## 5 Geochemistry

### 5.2 Response to submissions

Acid Generation Potential
Cobbora Coal Project - Acid and metaliferous drainage assessment
Figure 6.1

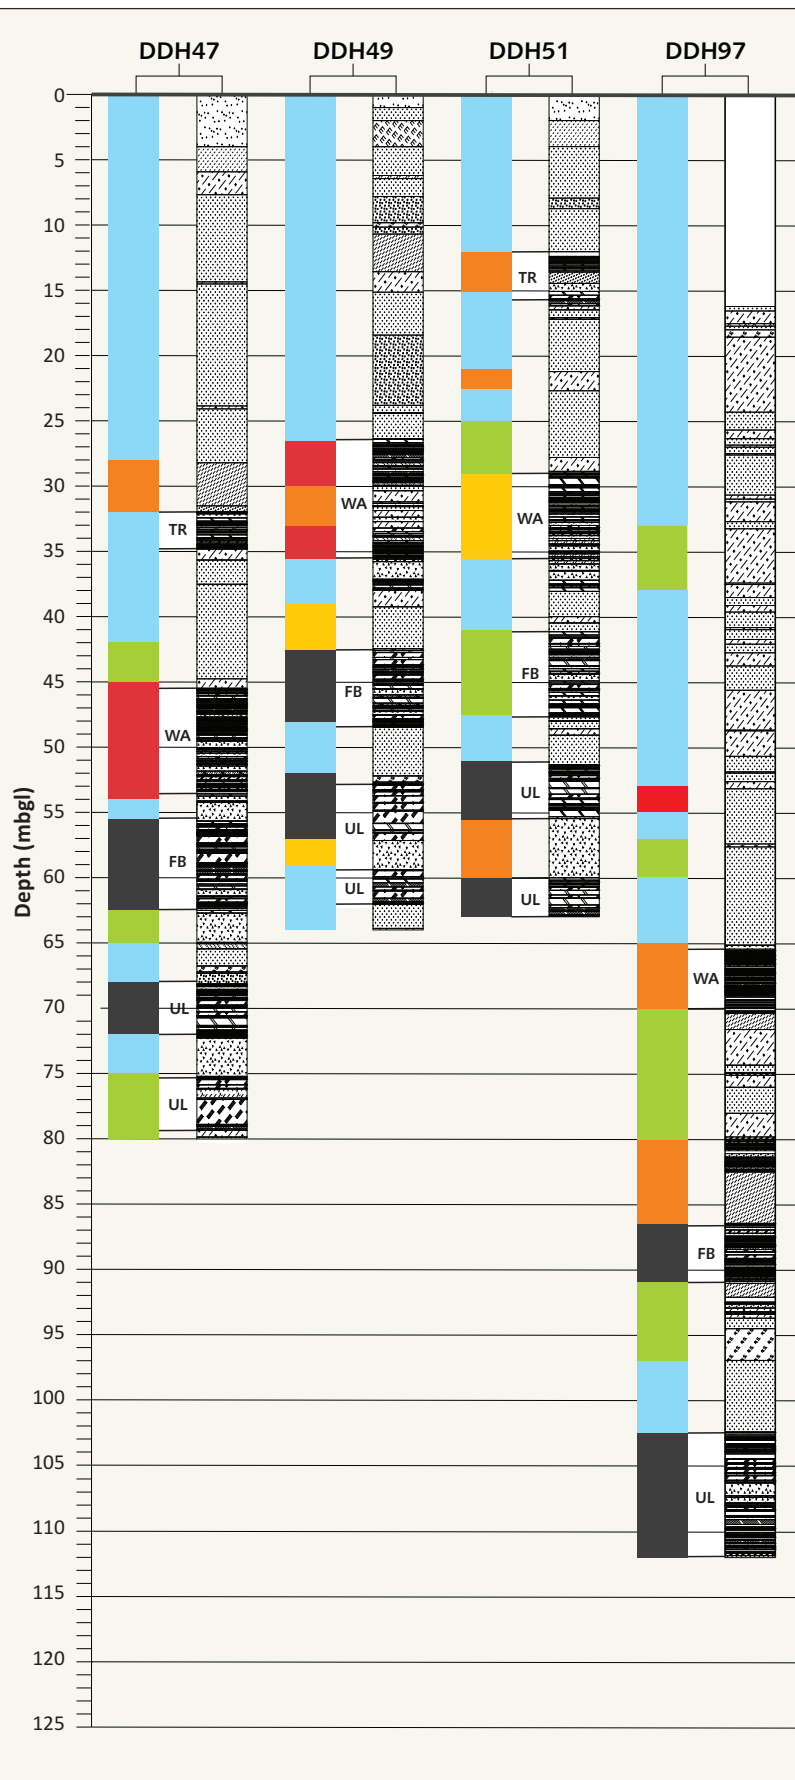
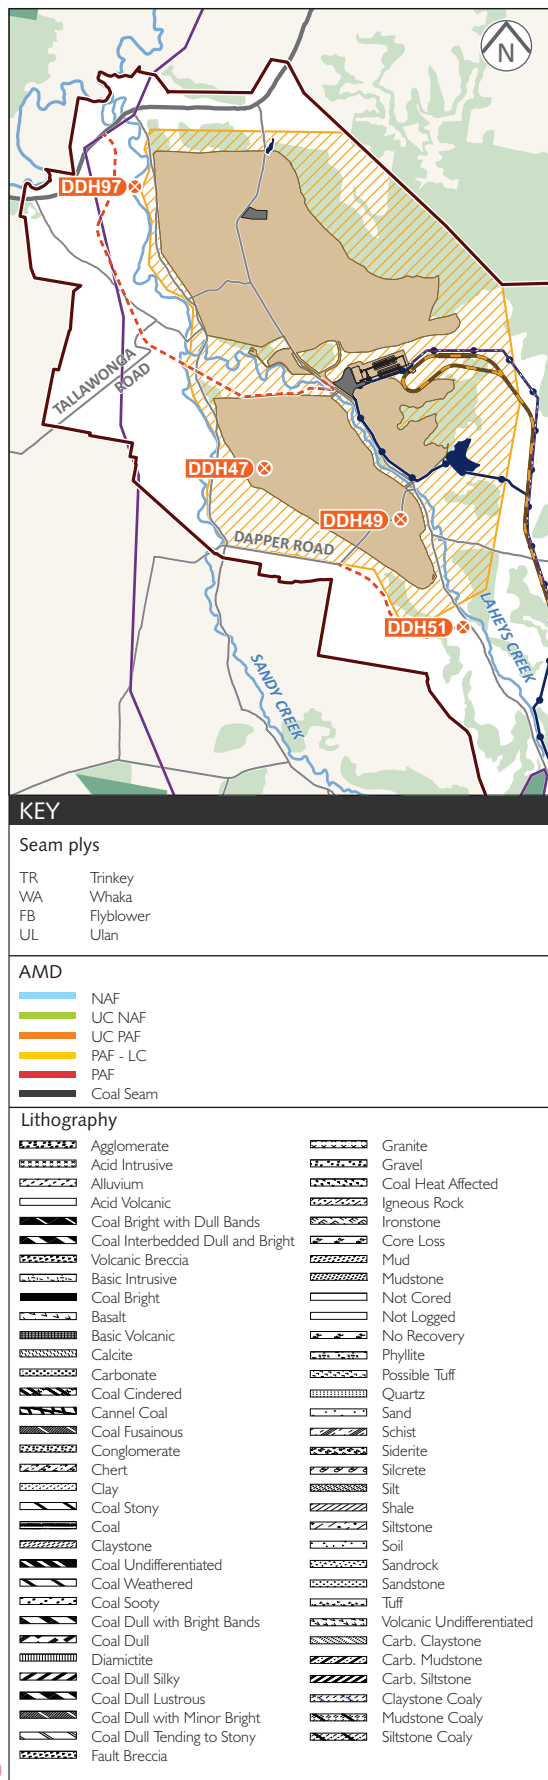
The DP&I comments that the acid and metalliferous drainage (AMD) assessment is based on samples from a limited number of cores, two of which are outside of the mining area and none of which are from Mining Area C. A justification for sampling effort should be provided.

As described in the main EA (Section 6.2), 59 discrete lithological samples from four cores and 11 washery waste samples were analysed. These cores were collected along a 14-km long north-west to south-east transect passing through Mining Areas A and C. As can be seen in the main EA (Figure 6.1), there is no significant variability in the AMD characteristics between these cores. The composition of strata in Mining Area B is similar to that in the other mining areas and AMD characteristics are expected to be similar.
